## **BCA (incl. ACCESS) ASSESSMENT REPORT**

**813 Wallgrove Road  
Eastern Creek**

**Prepared For:  
DHL Supply Chain**

Date: 28 February 2022

DRAWING NO:
DA02

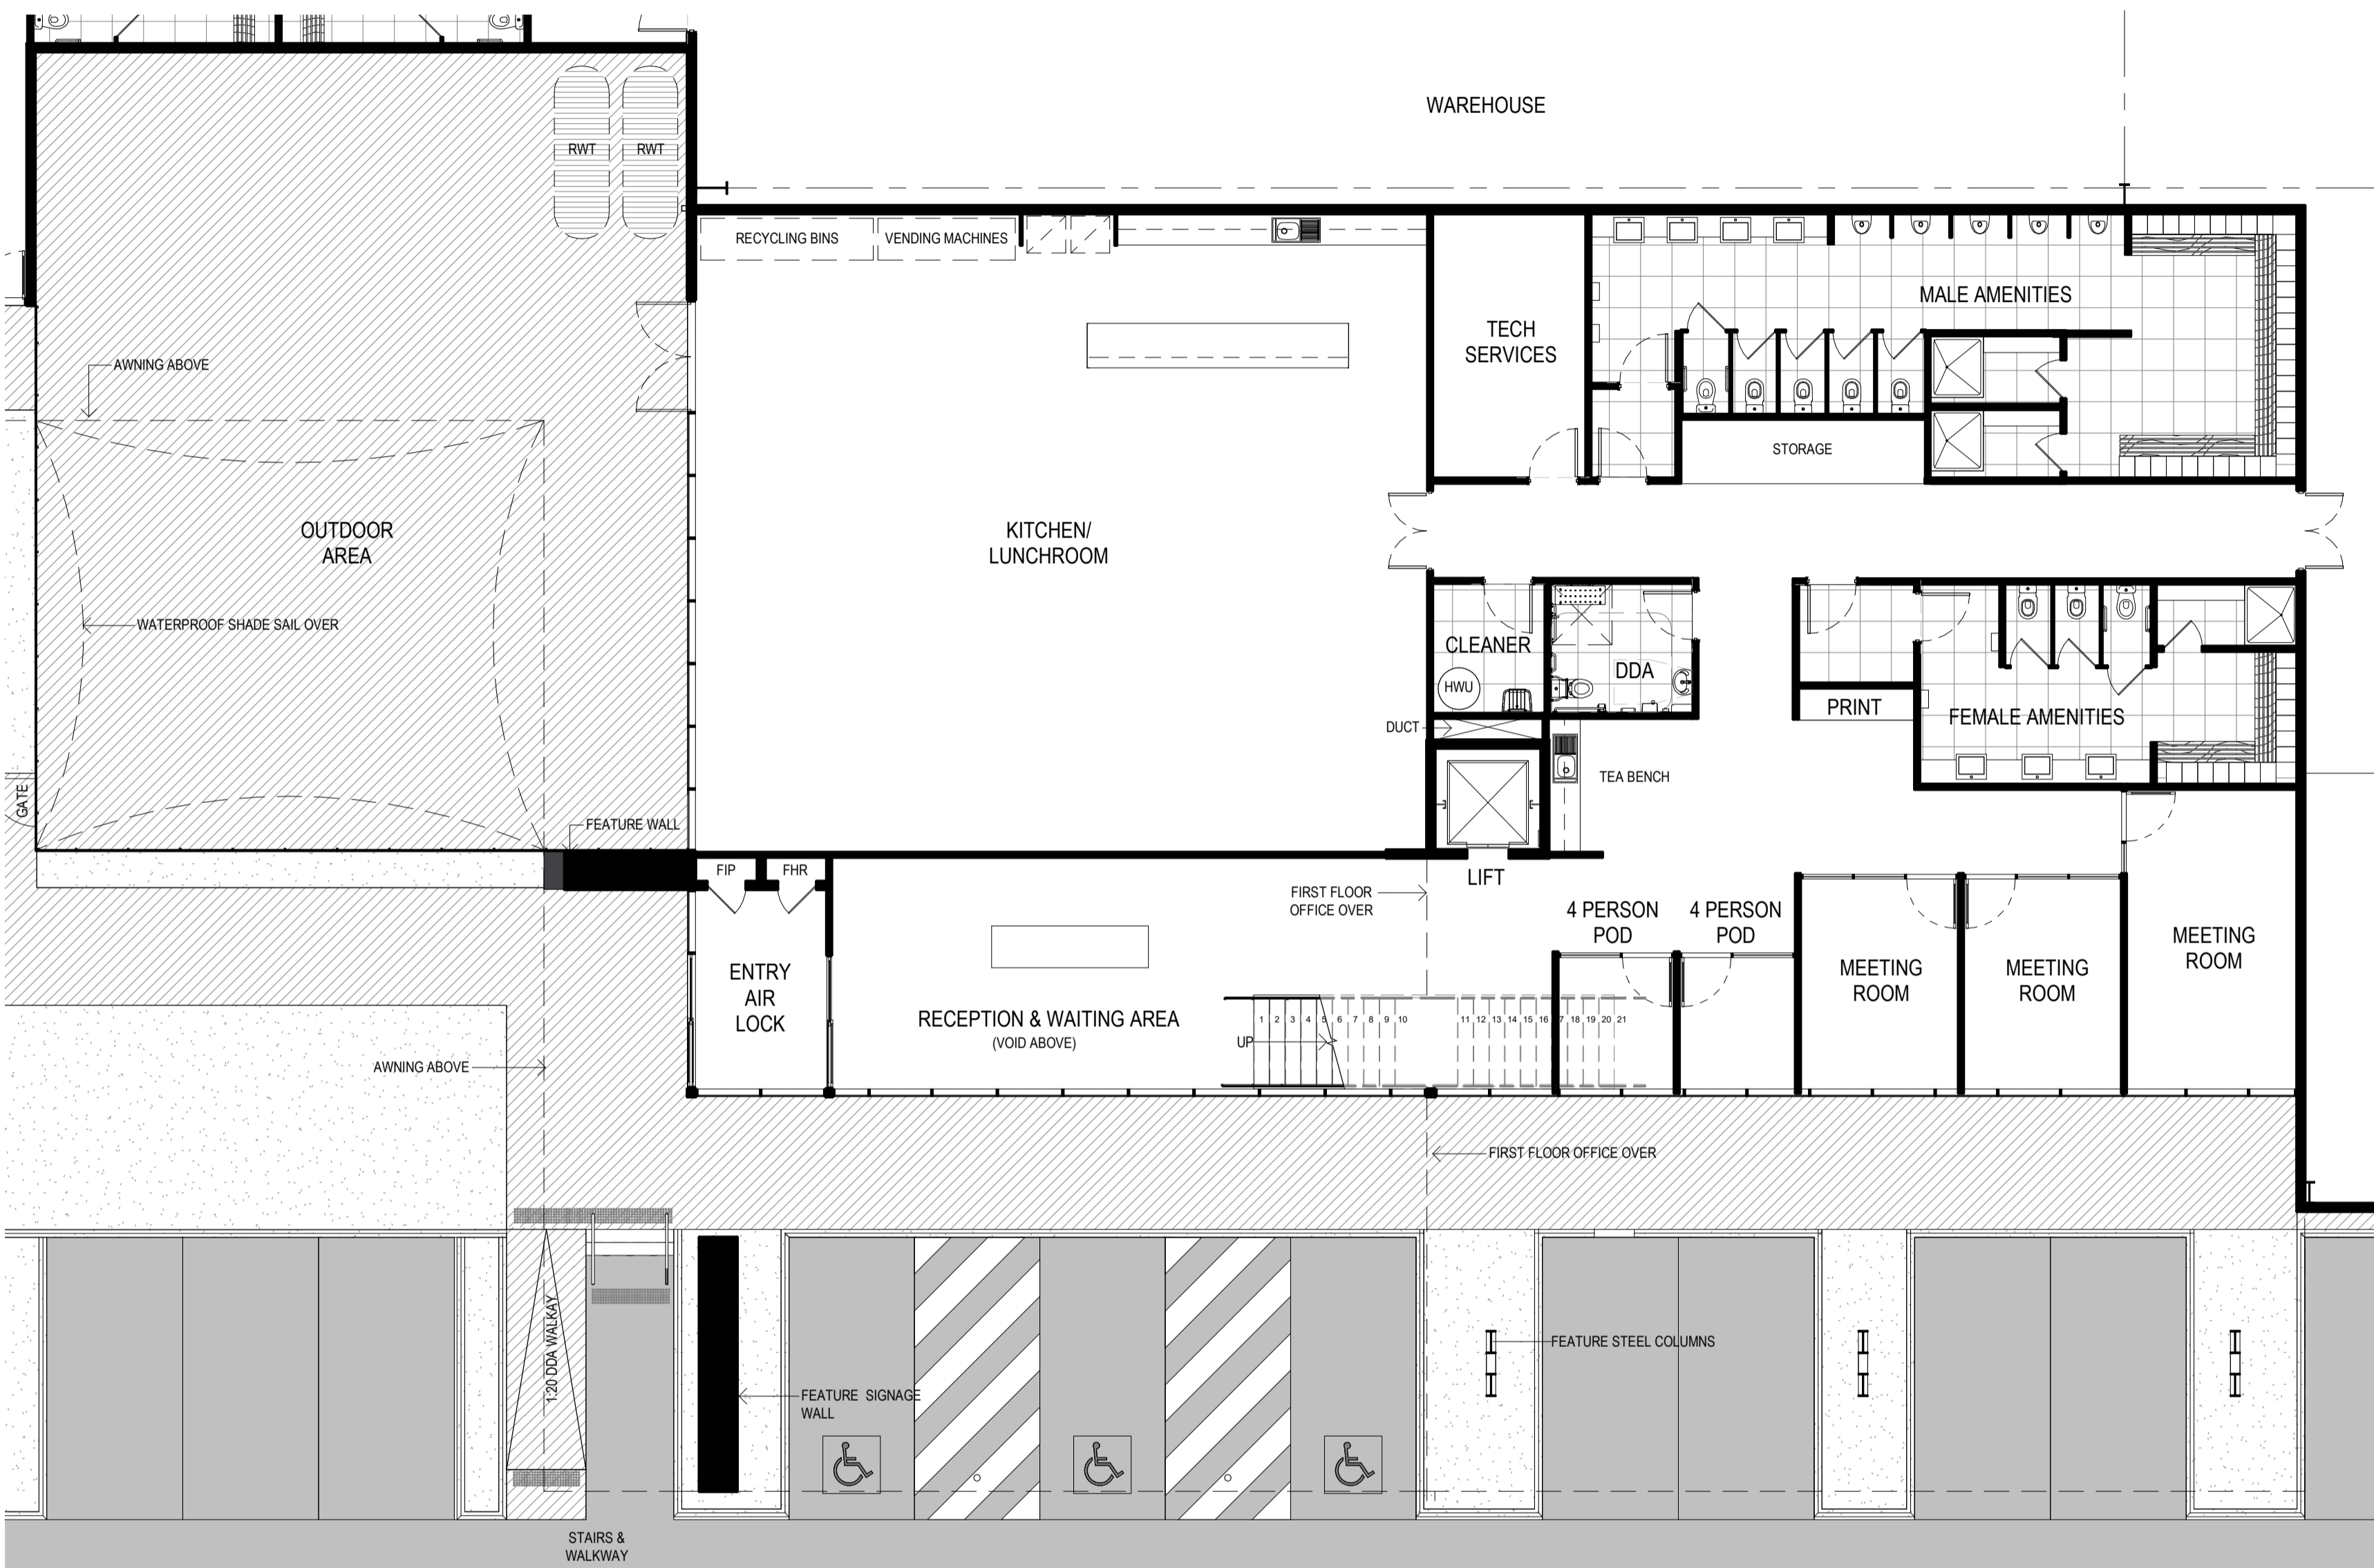
*Comments: The proposed Warehouse building does not comply with the provisions of C2.4 and thus the following non-compliance issue is required to be addressed as a Performance Solution by the Fire Engineer to demonstrate compliance with Performance Requirement CP9:*

- + *Perimeter Vehicular Access (PVA) is greater than 18m from the external walls along the southern side of the building off the proposed Estate Road – see Figure 1 over page.*
- + *PVA on the eastern side of the building is open, however it passes under the structural steel frame of the x2 super awning structures that are located over the loading areas on this side of the building, which is not strictly compliant with C2.4(b)(iv).*

Note 1: Any proposed sliding gates are to achieve no less than 6m unobstructed width or the reduced width will need to be included in the above Performance Solution.

Note 2: The driveways providing vehicular perimeter access must be designed with adequate loading capacities to withstand a fire truck and the gradients of any ramps and swept paths should take into consideration the requirements of the FRNSW Fire Safety Guideline – Access for Fire Brigade Vehicles and Firefighters.
